Your ref:
Our ref: 21/01993/F
Please ask for: Mrs Rebecca Bush
Direct dial: 01553 616825
Direct fax: 01553 616652
E-mail: borough.planning@west-norfolk.gov.uk

Details: **Demolition of existing side extensions. Construction of 2 storey side extension and single storey front porch at Lumbertubs 7 Wheatley Drive North Wootton King's Lynn Norfolk**

PROJECT 7 WHEATLEY DRIVE, KING'S LYNN, NORFOLK, PE30 3QQ.	CLIENT MR & MRS EASEY	DWG No. 2106007-03	REVISION P5
DRAWING PROPOSED FLOOR PLANS		DISCIPLINE PLANNING

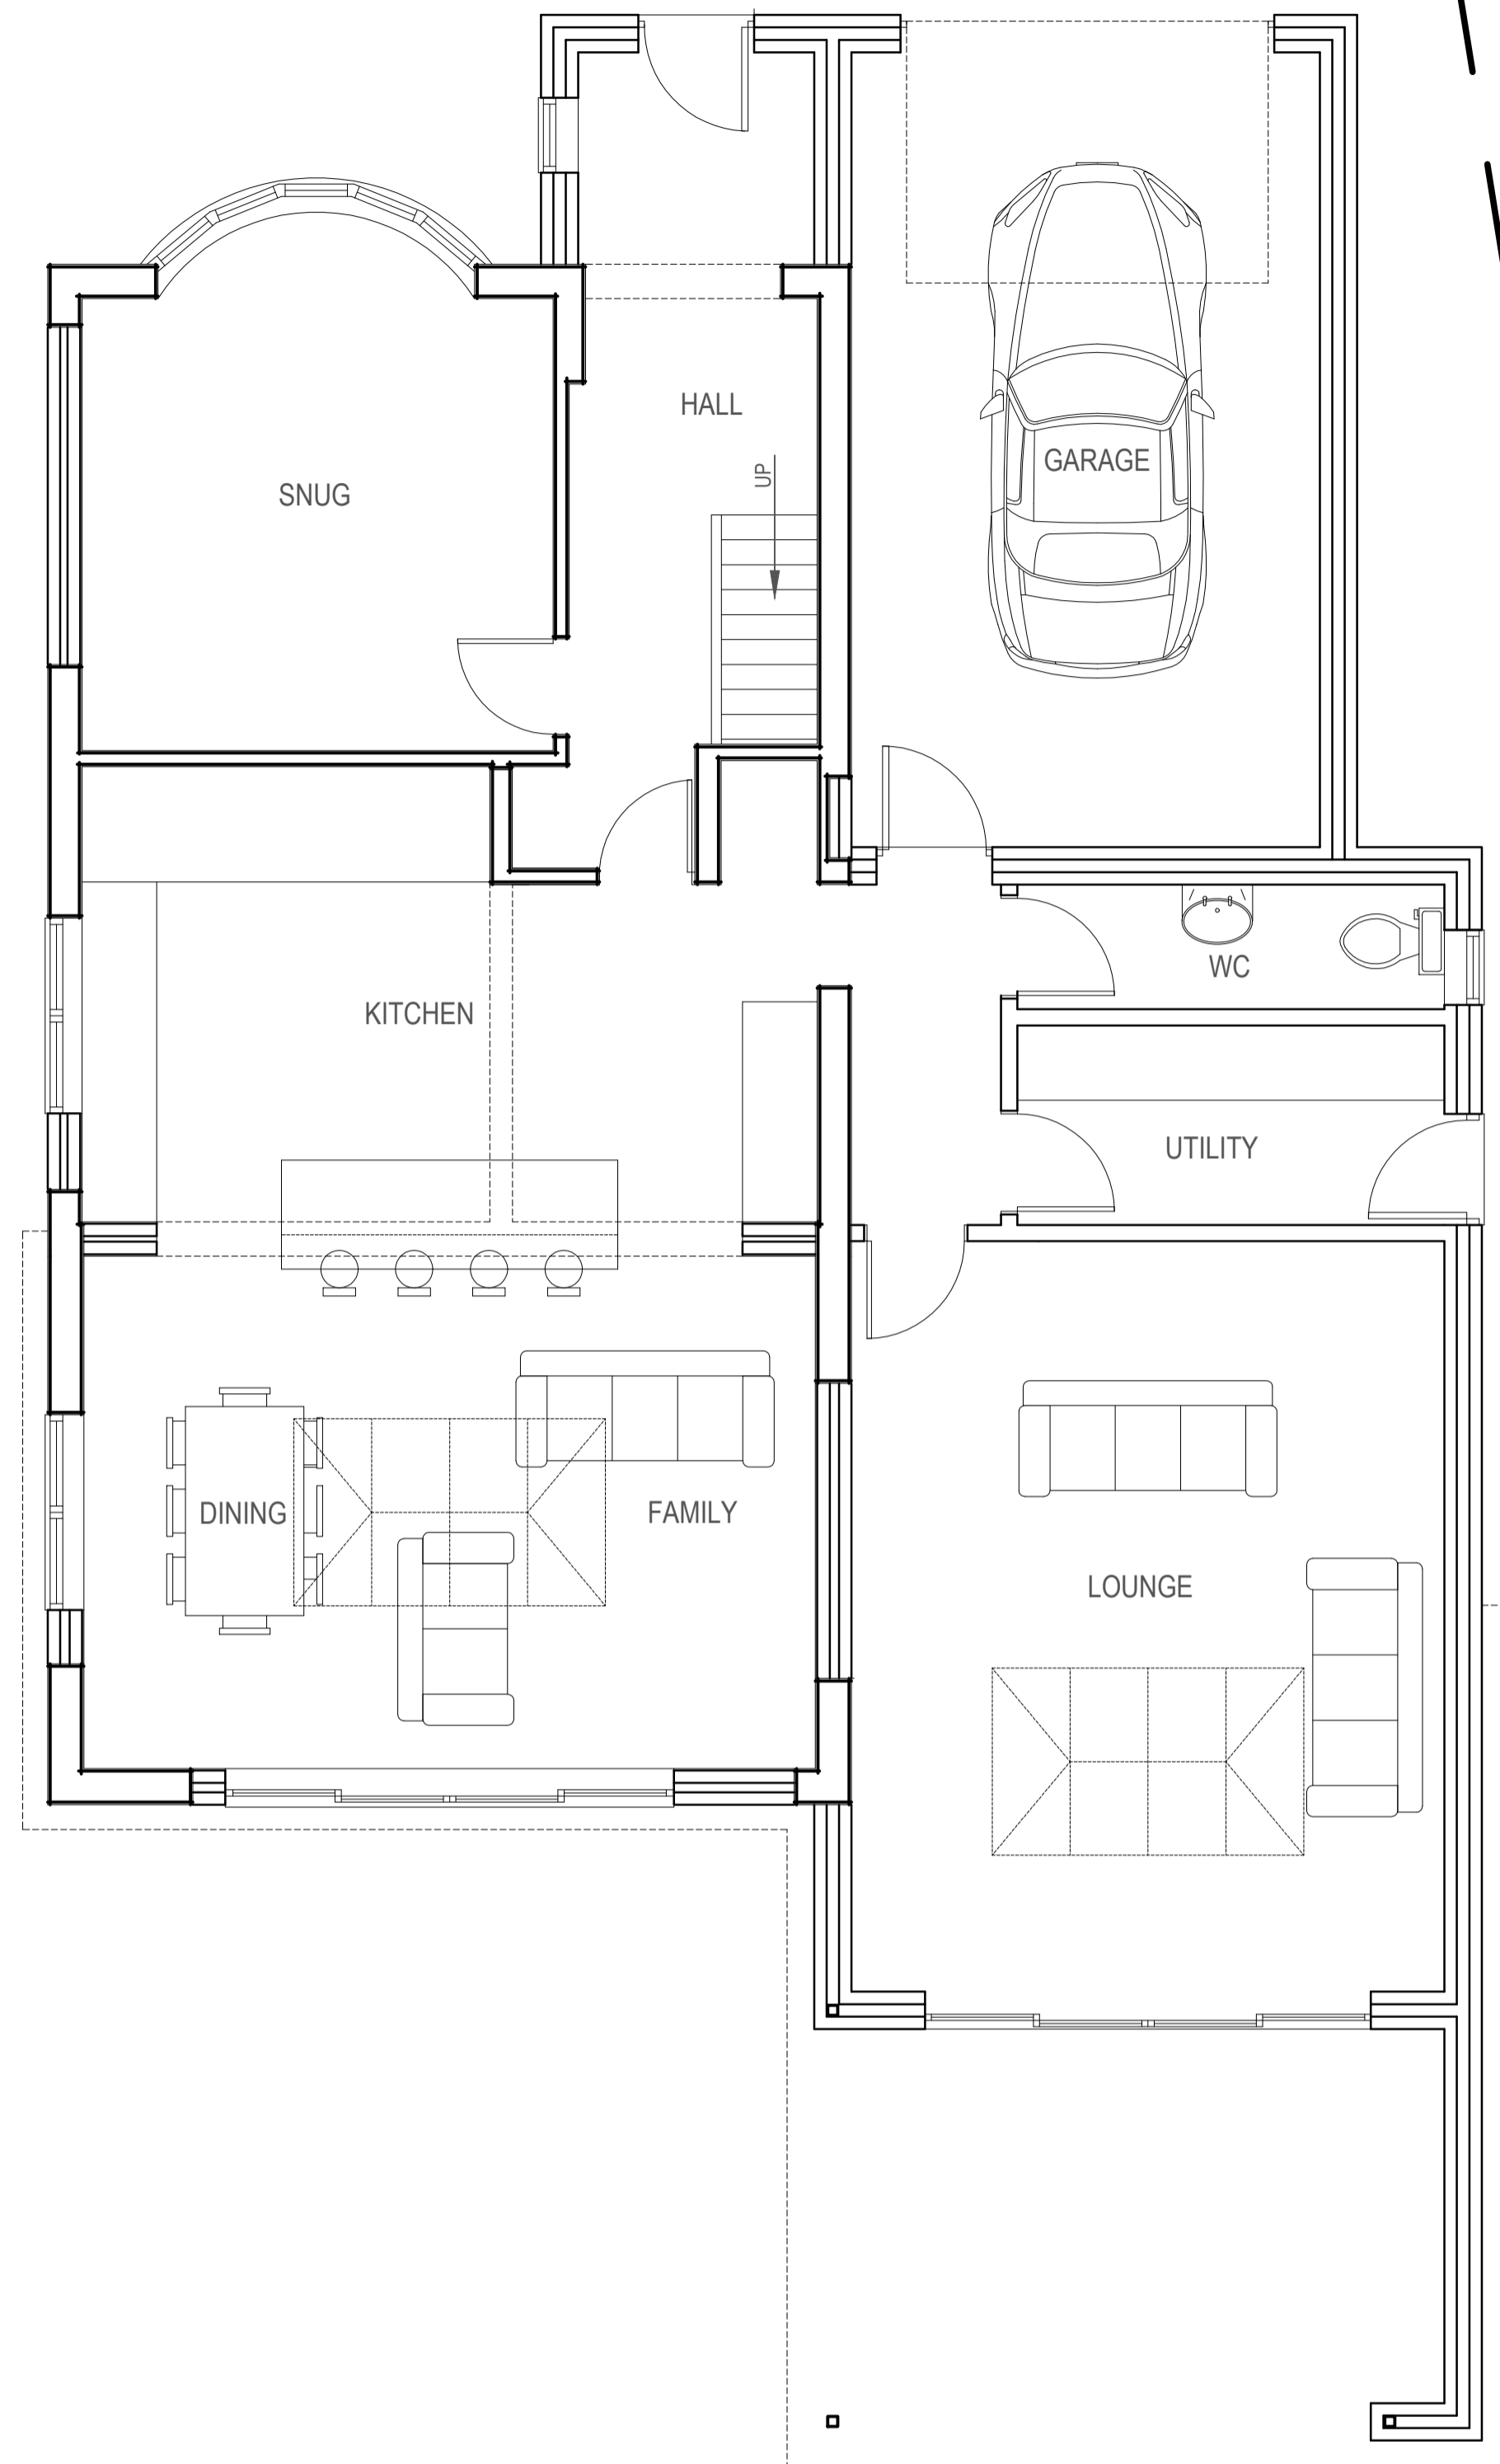
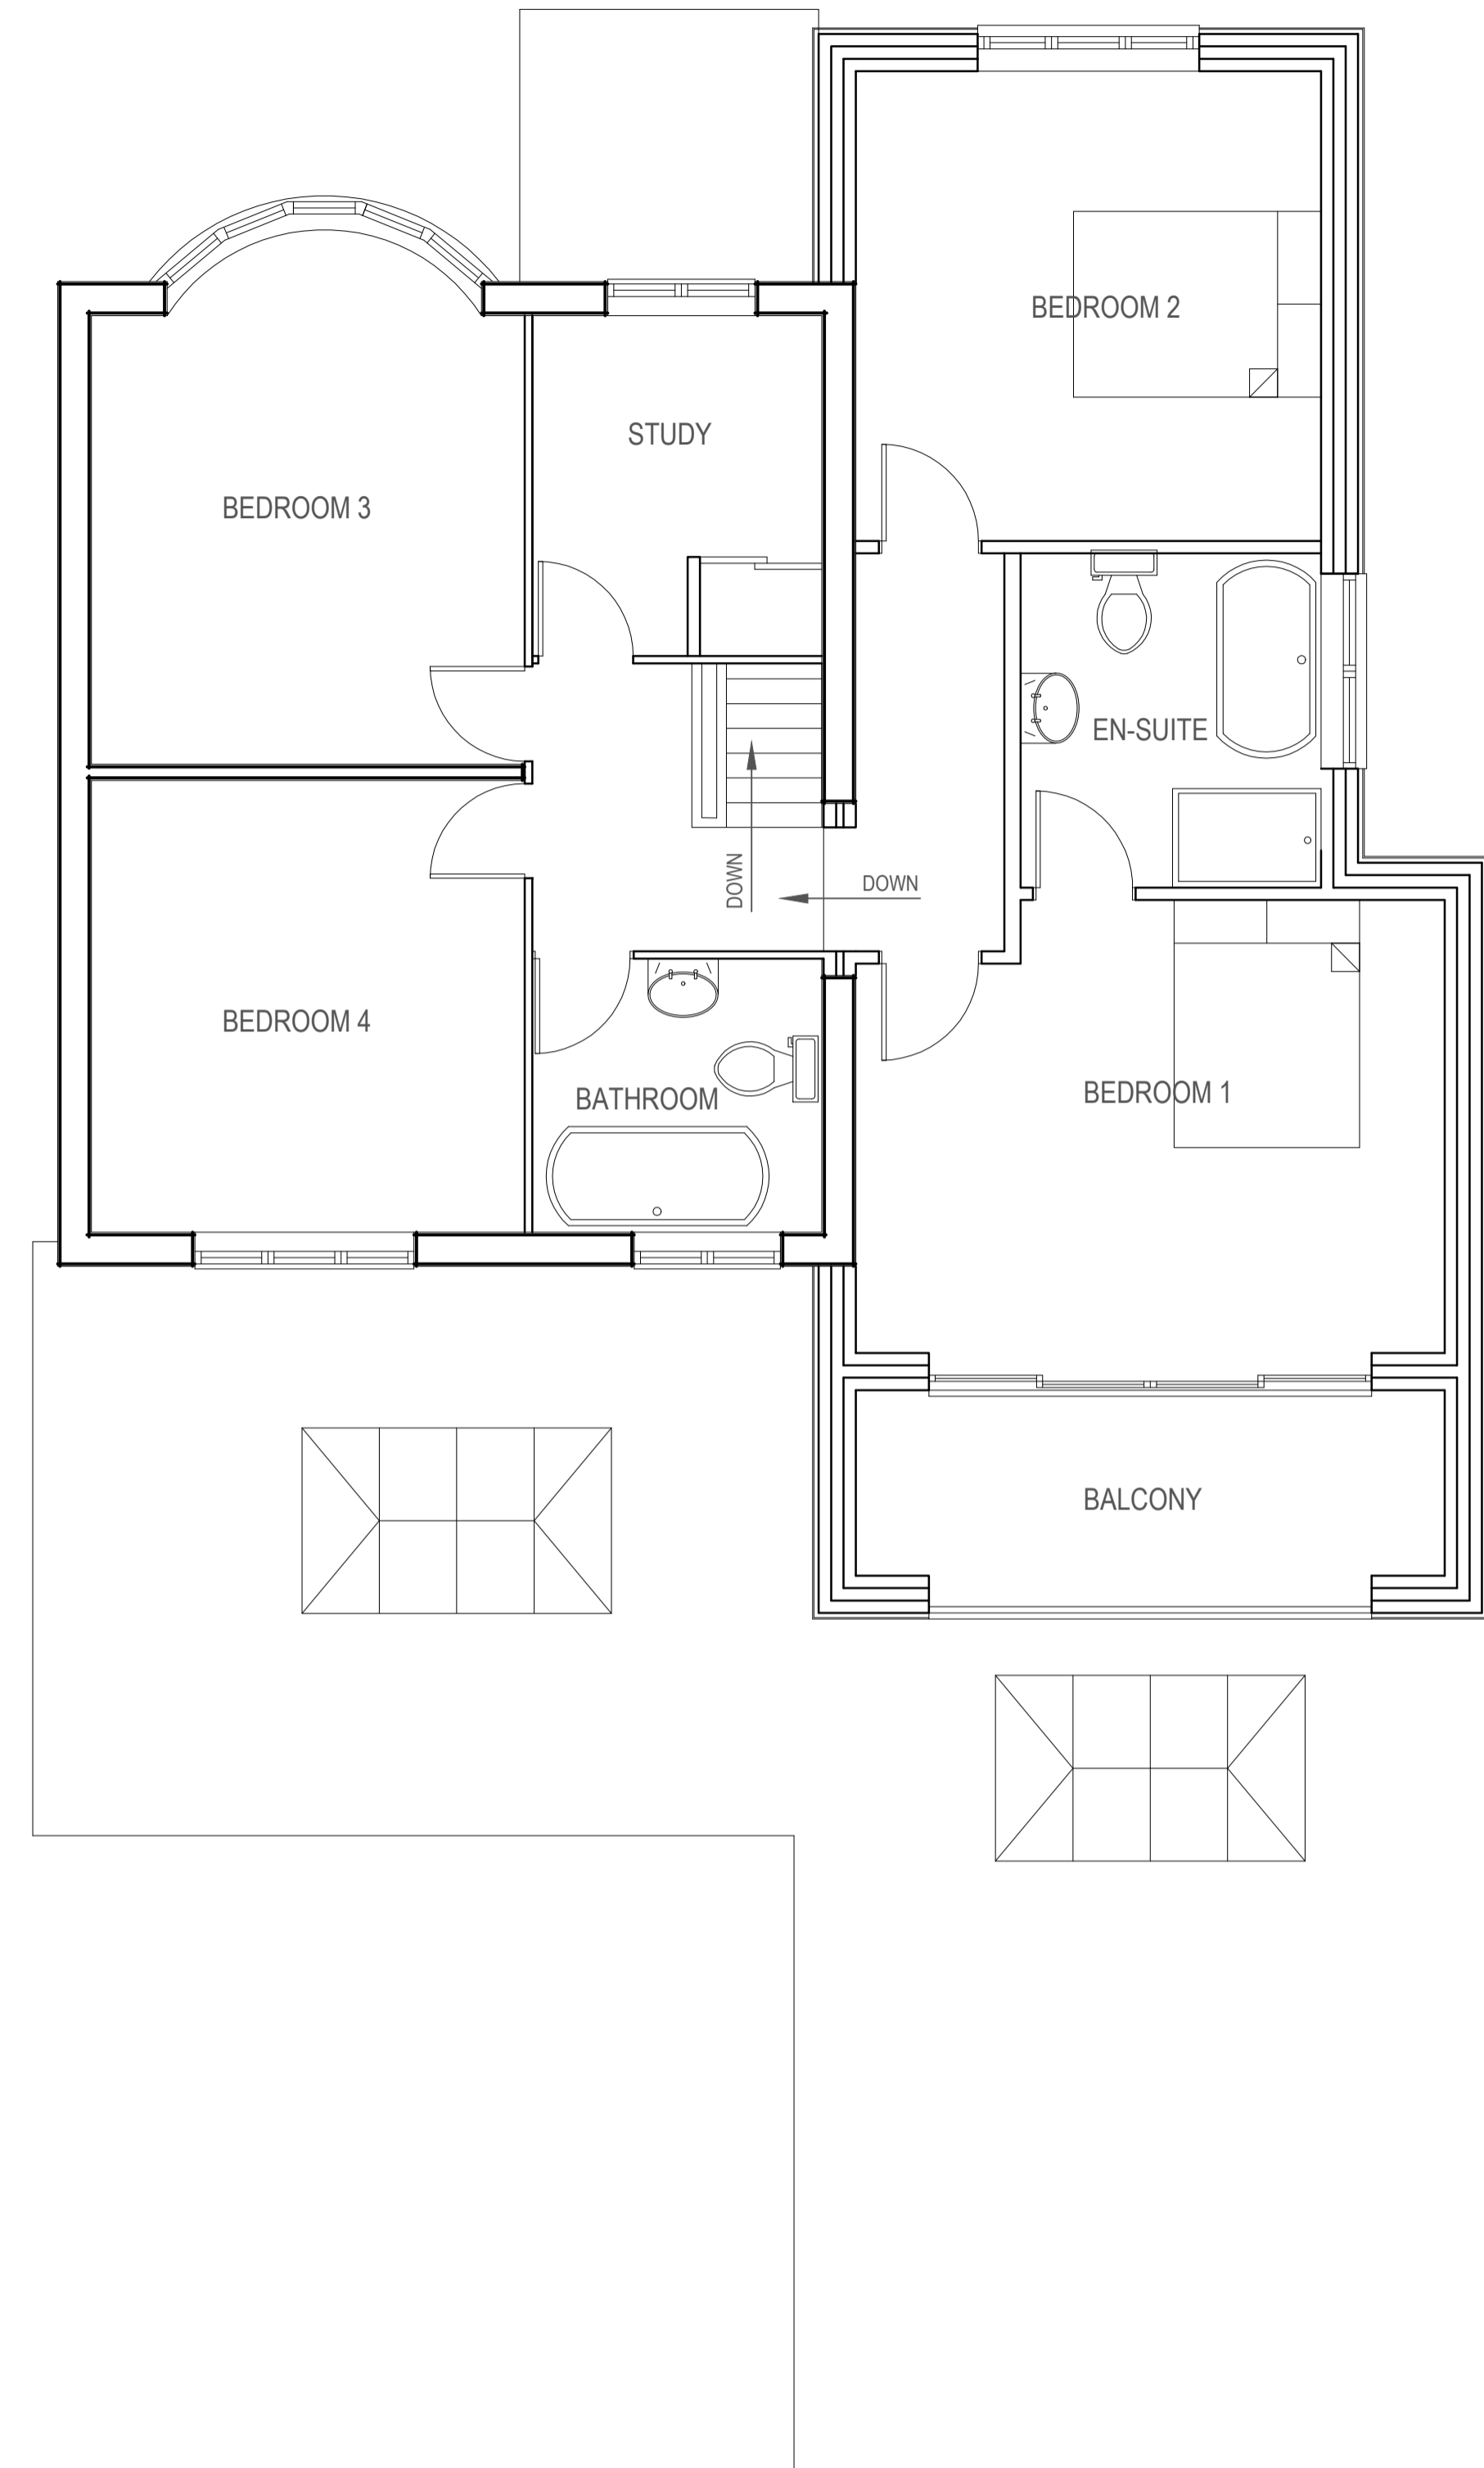
1. We will require a block plan/roof plan to a scale of 1:500 or 1:200 showing site boundaries and the new work.
2. Please provide four copies of a drawing, to a recognisable scale, showing a section through the new extension.
3. In accordance with the National Validation Checklist, which became mandatory on 6 May 2008, we will require information regarding site levels. If site levels are to change, please provide four copies of a site survey drawing, alternatively, if site levels are to remain unchanged, this can be annotated on the relevant plan or advised in writing.
4. As the property lies within an area at risk to flooding, please complete the simplified Matrix and return it. The Matrix can be found at https://www.west-norfolk.gov.uk/info/20173/information_for_planning_agents/231/flood_risk_information
